YorkshireWater

Our Ref: U002955

Former William Freeman Site, Wakefield Road, Mapplewell - Residential development for up to 85 dwellings with associated infrastructure and access (Outline with All Matters Reserved apart from access)

Drainage Strategy

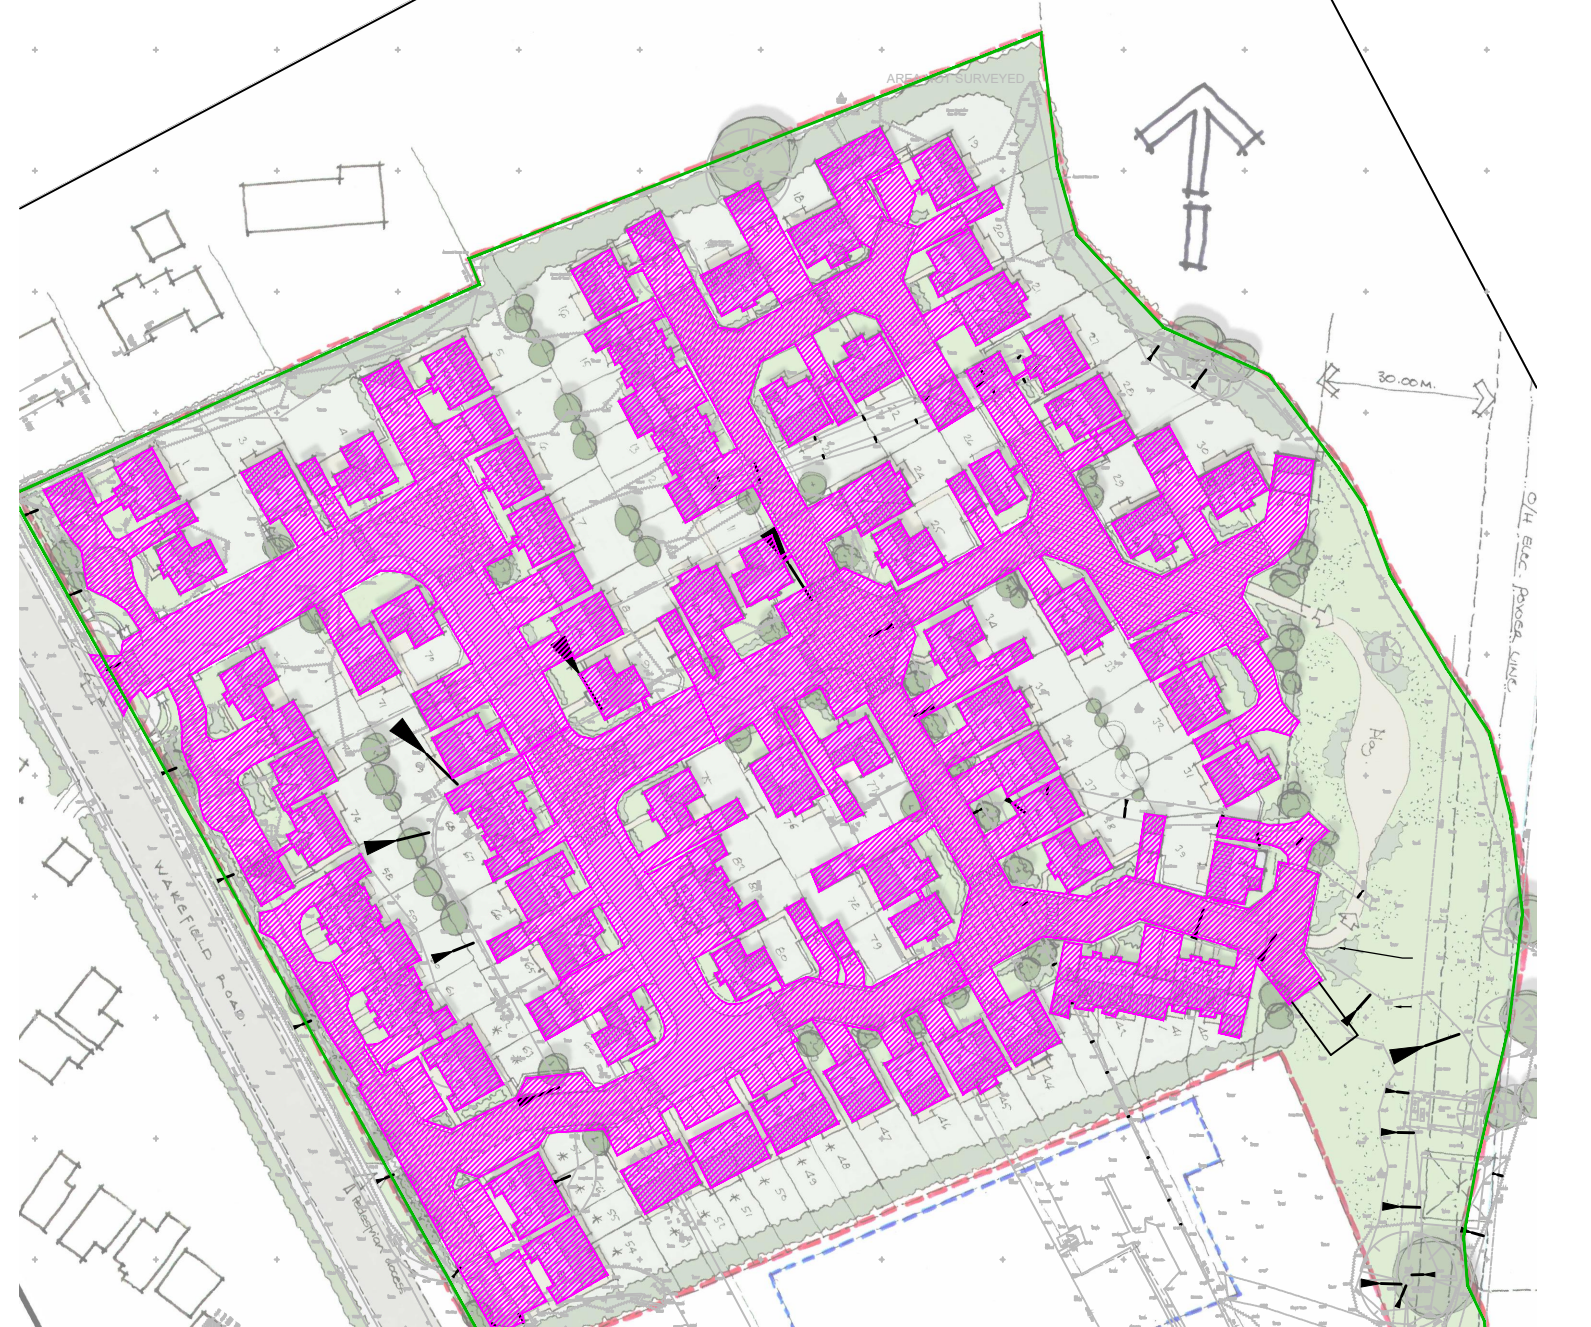
1) Development of the site should take place with separate systems for foul and surface water drainage. The separate systems should extend to the points of discharge to be agreed. From the information supplied, it is not possible to determine if the whole site will drain by gravity to the public sewer network. If the site, or part of it, will not drain by gravity, then it is likely that a sewage pumping station will be required to facilitate connection to the public sewer network. If sewage pumping is required, the peak pumped foul water discharge must not exceed 6 (six) litres per second.

2) It is noted from the submitted planning application and supporting FRA that surface water is proposed to be drained to watercourse. An off-site surface water sewer may be required. This may be provided by the developer and considered for adoption by means of a sewer adoption agreement under Section 104 of the Water Industry Act 1991. Alternatively, the developer may in certain circumstances be able to requisition off-site sewers under Section 98 of the Water Industry Act 1991.

As surface water from the site is not proposed to discharge to the public sewer network, no assessment of the capacity of the public sewers to receive surface water has been undertaken. Should the surface water disposal proposals change, further consultation with Yorkshire Water will be required.

The site shall be developed with separate systems of drainage for foul and surface water on and off site. If sewage pumping is required, the peak pumped foul water discharge shall not exceed 6 (six) litres per second.

No piped discharge of surface water from the application site shall take place until works to provide a satisfactory outfall, other than the existing local public sewerage, for surface water have been completed in accordance with details submitted to and approved by the Local Planning Authority . (To ensure that the site is properly drained and in order to prevent overloading, surface water is not discharged to the foul sewer network)
